DRB Application No.: <u>04DRB-00209 (SBP)</u>	Project # <u>1002333</u>
Project Name: <u>Bellamahs Princess Jeanne</u>	
Agent: <u>Dekker/Perich/Sabatini</u>	Phone No.: <u>761-9700</u>

DEKKER/PERICH/SABATINI agent(s) for THE BARRETT FOUNDATION request(s) the above action(s) for all or a portion of Block(s) 10A, Tract(s) C-1-A-2, **BELLAMAH'S PRINCESS JEANNE PARK ADDITION**, zoned C-1, located on CONSTITUTION AVE NE, between EUBANK NE and MARY ELLEN ST NE containing approximately 2 acre(s). [REF: 1002333, 02EPC-01691, 02EPC-01693, Z-870, DRB-94-619] **[Cynthia Borrego, EPC Case Planner]** *[Deferred from 2/25/04 & 3/3/04]* (J-21) **SITE PLAN FOR BUILDING PERMIT WAS APPROVED AND DELEGATED TO PLANNING FOR CYNTHIA BORREGO'S INITIALS AND INFRASTRUCTURE LIST STATEMENT ON SIGNATURE BLOCK.**

Thank you for the opportunity to review the submitted Site Development Plan. Staff has the following comments prior to final sign-off by the DRB:

SITE LIGHTING FIXTURE POLE STANDARD MOUNTING

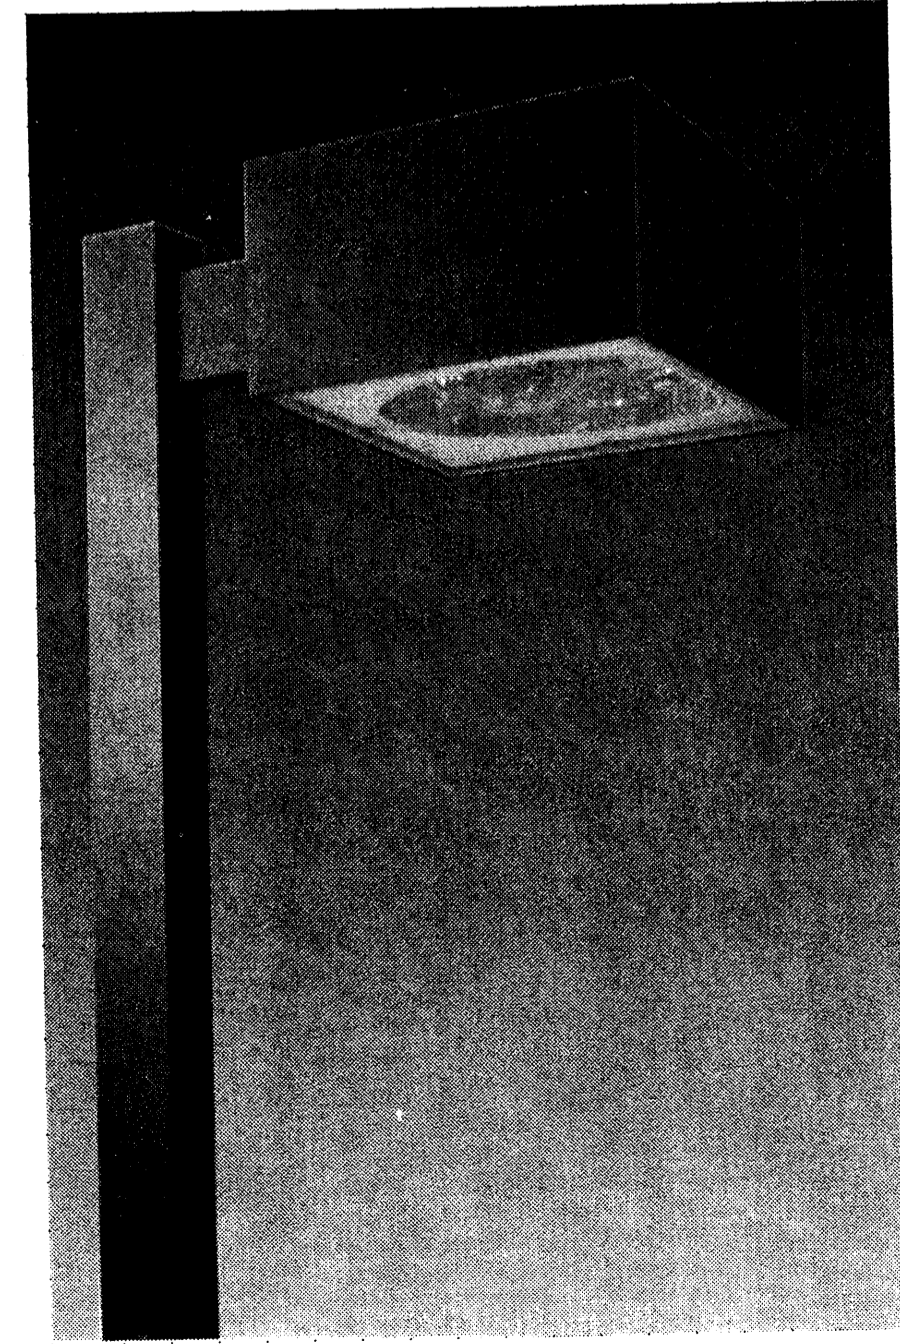
The applicant is required to meet the requirements of the City Zoning Code Section 14-16-3-9 Area Lighting Regulations and the requirements of the City Street Tree Ordinance for the frontage along Constitution.

NEW GRAVEL BASE-COURSE PAVING AT EXISTING ALLEY

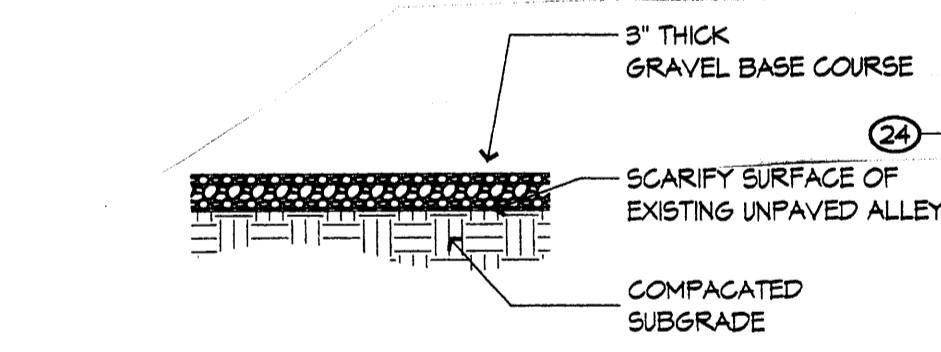
TRANSPORTATION: alley improvements

CONCEPT SITE PLAN

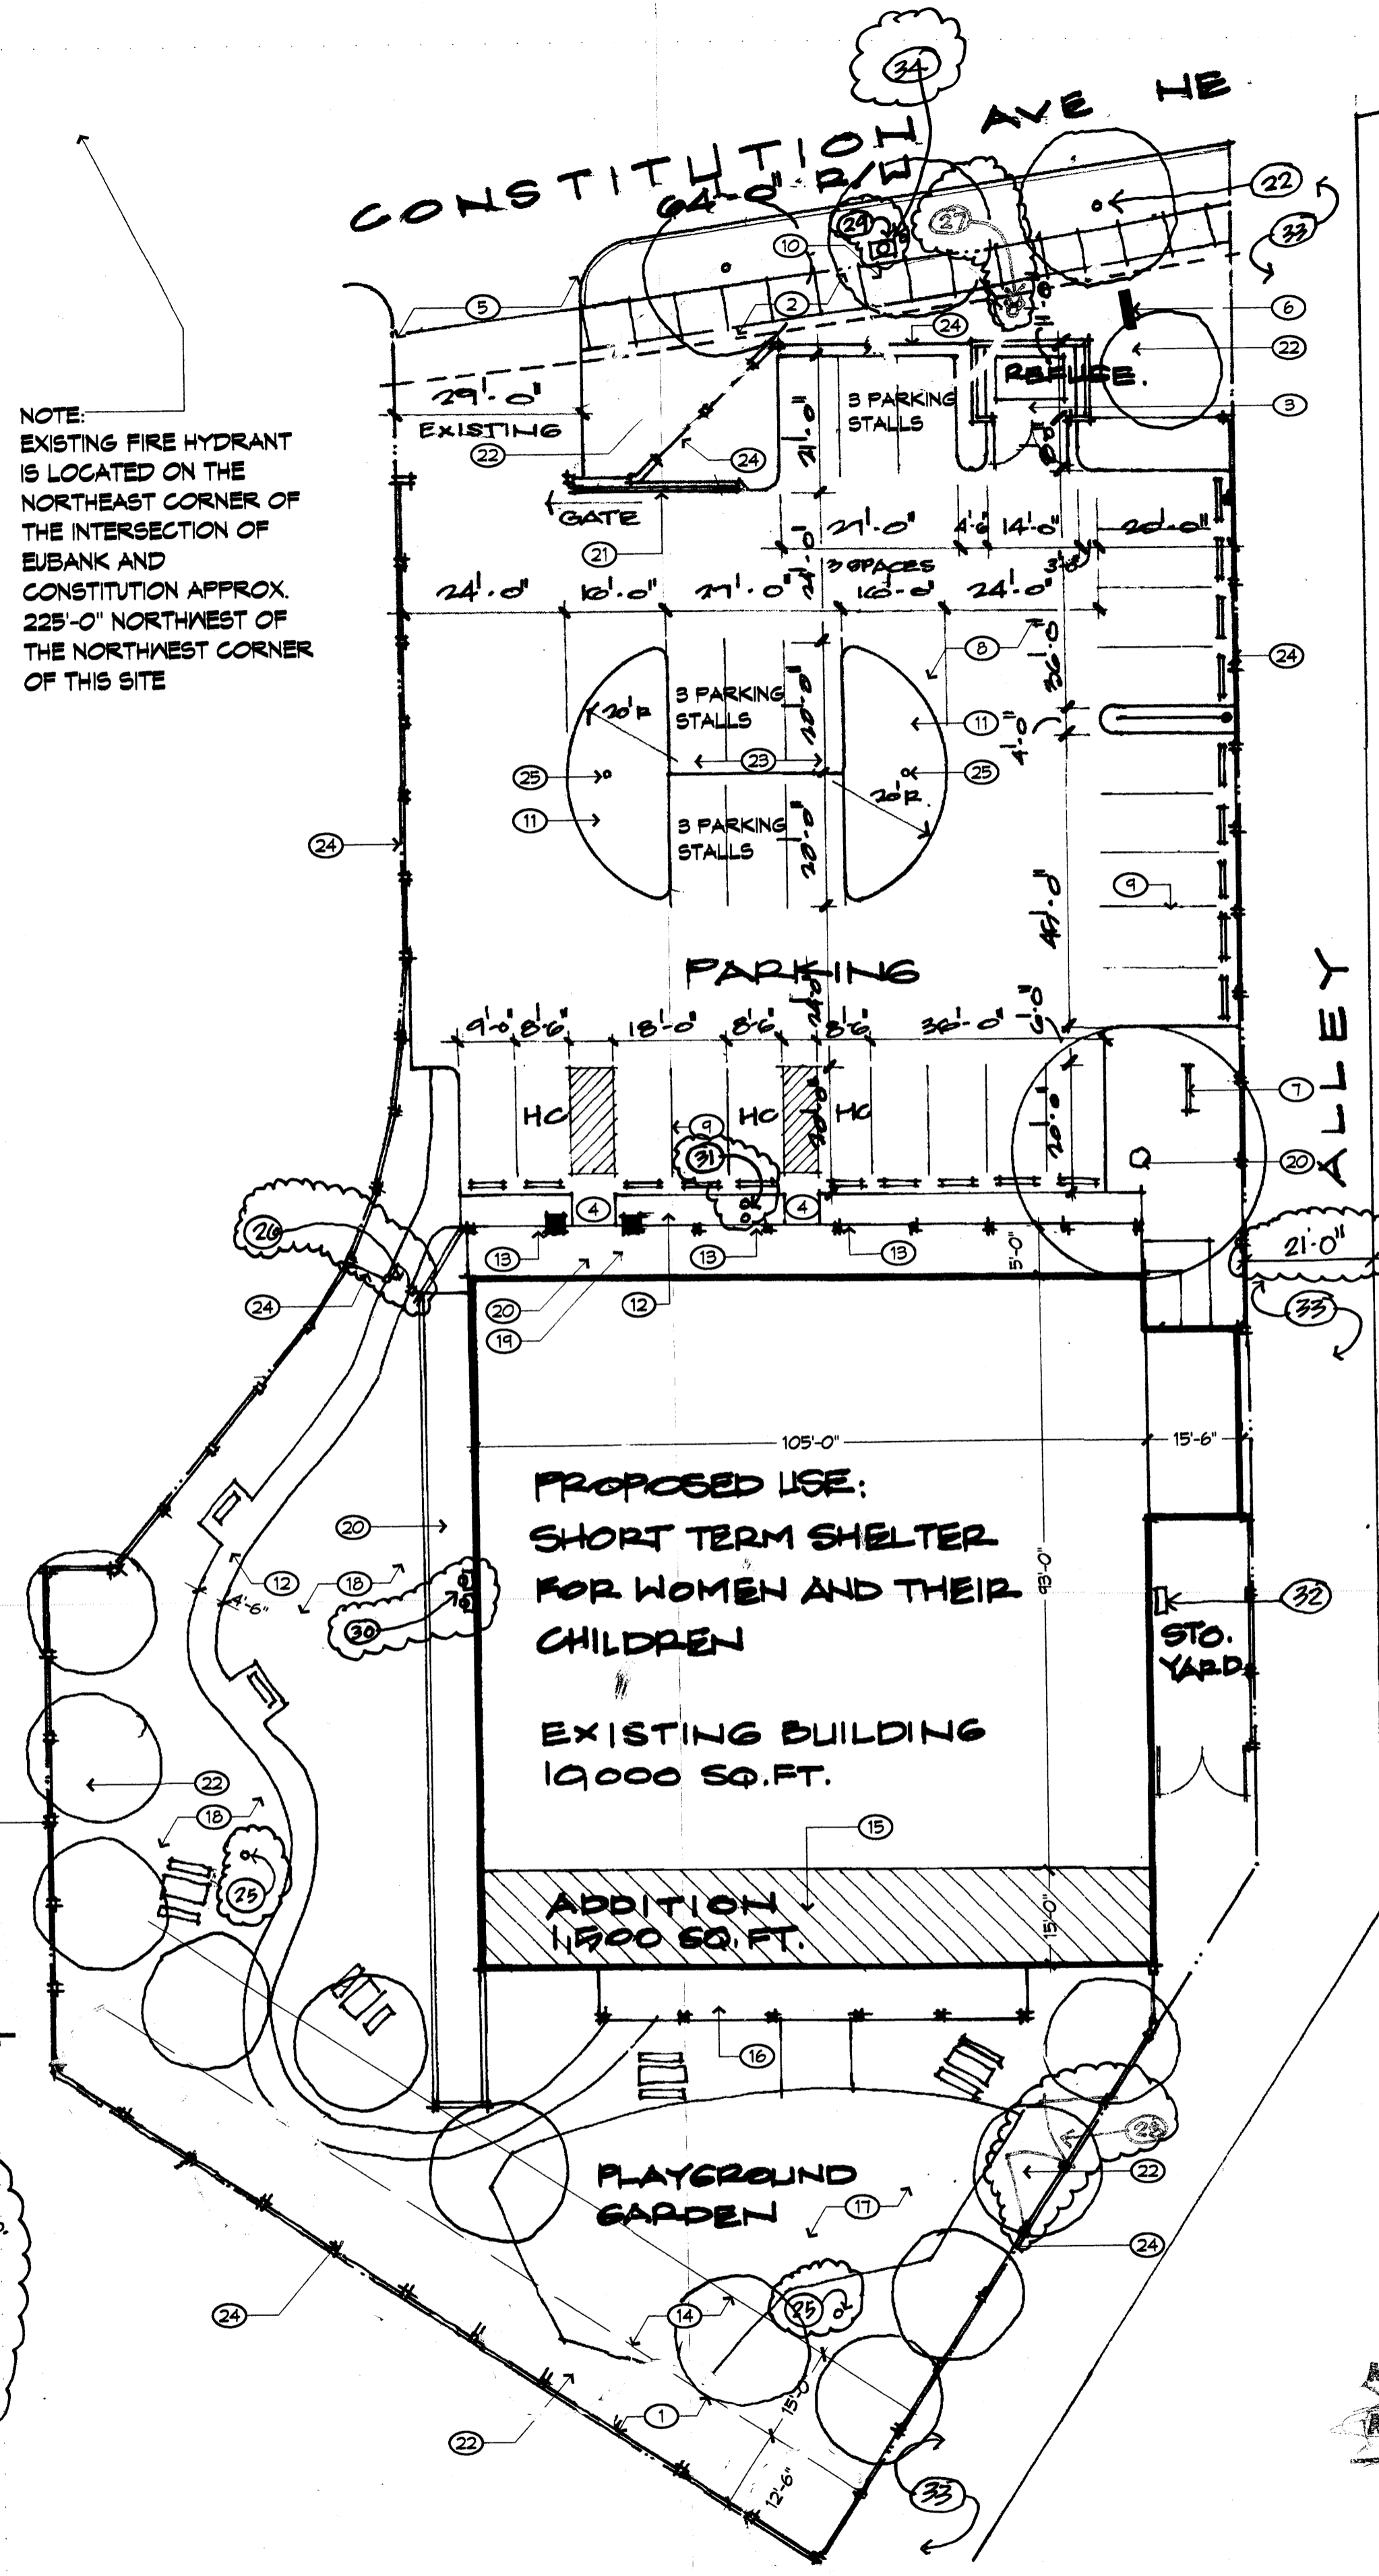
UTILITIES: landscaping encroaches on utility easements

PROPOSED ELEVATION @ NEW PATIO COVER

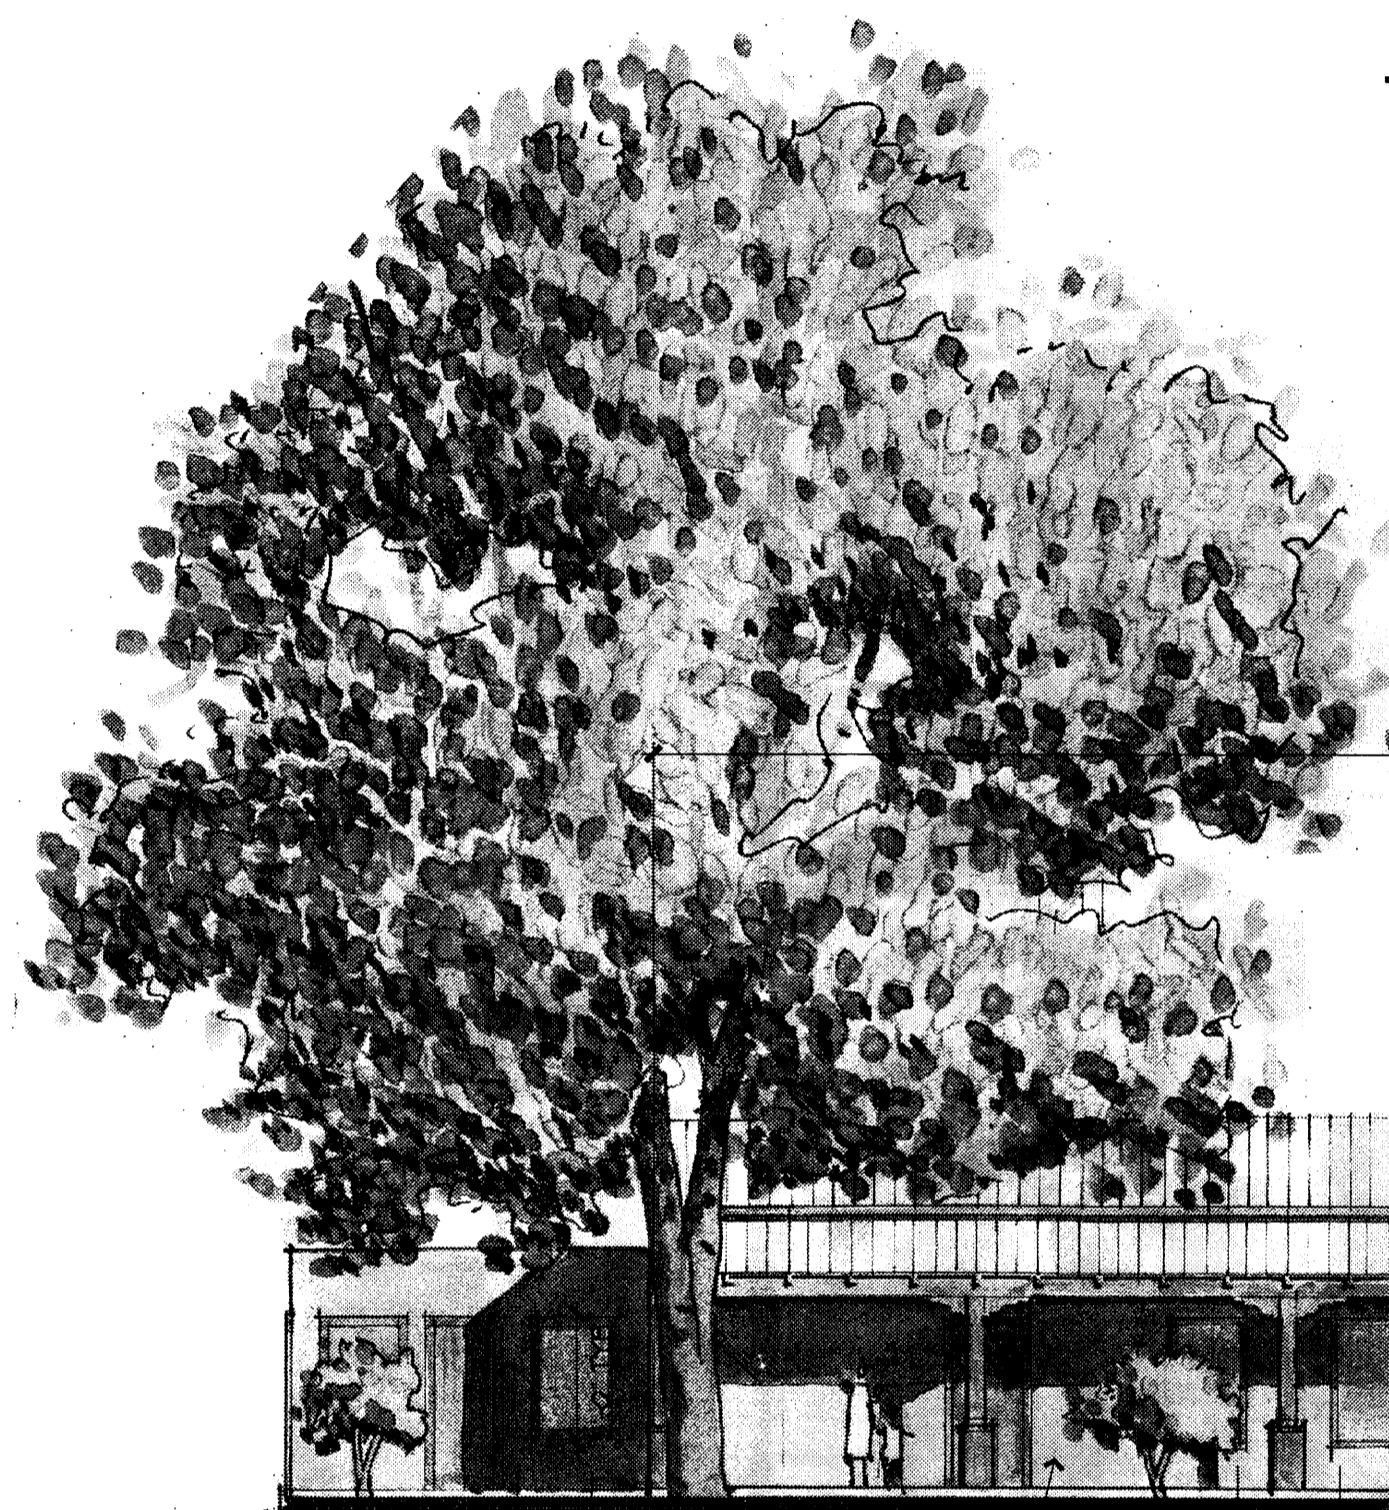
Details of the rear covered patio should be provided by the applicant prior to final sign off by the DRB.

*provided on sheet 2*

MONUMENT SIGN DETAIL

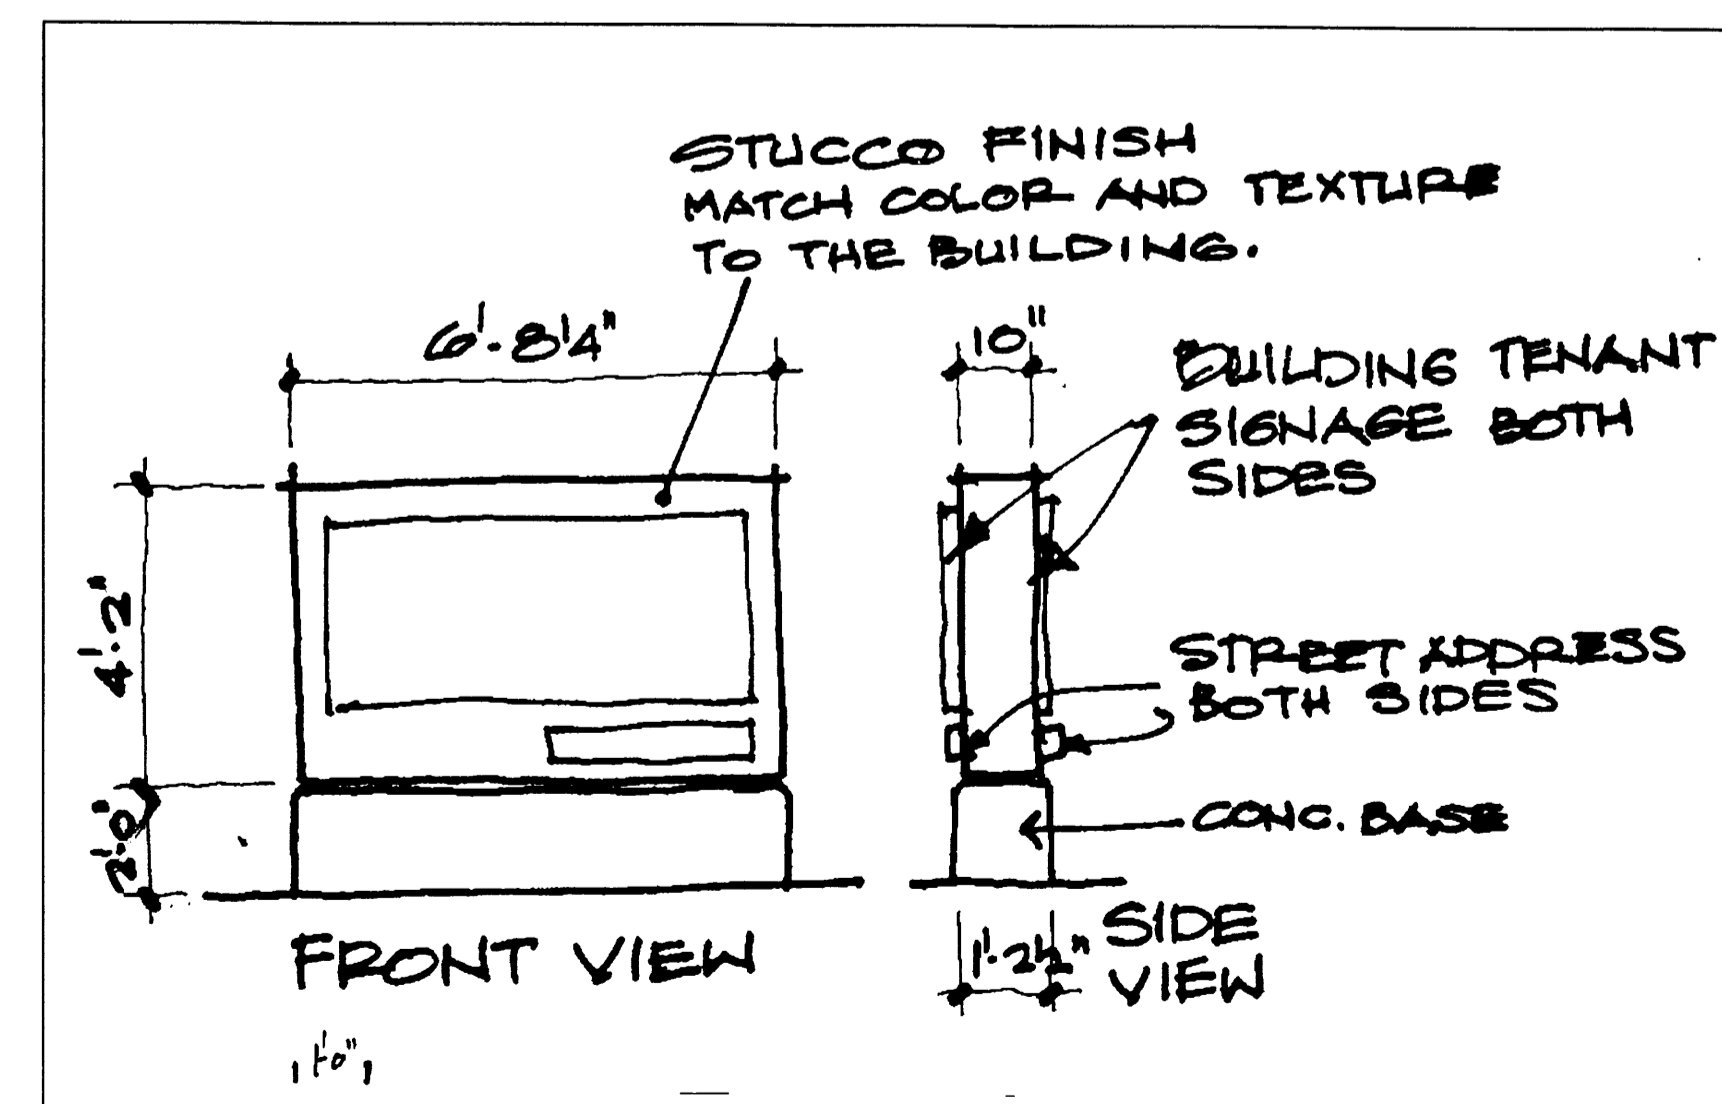
Sign detail dimensions should be specifically noted by the applicant on the final site development plan.
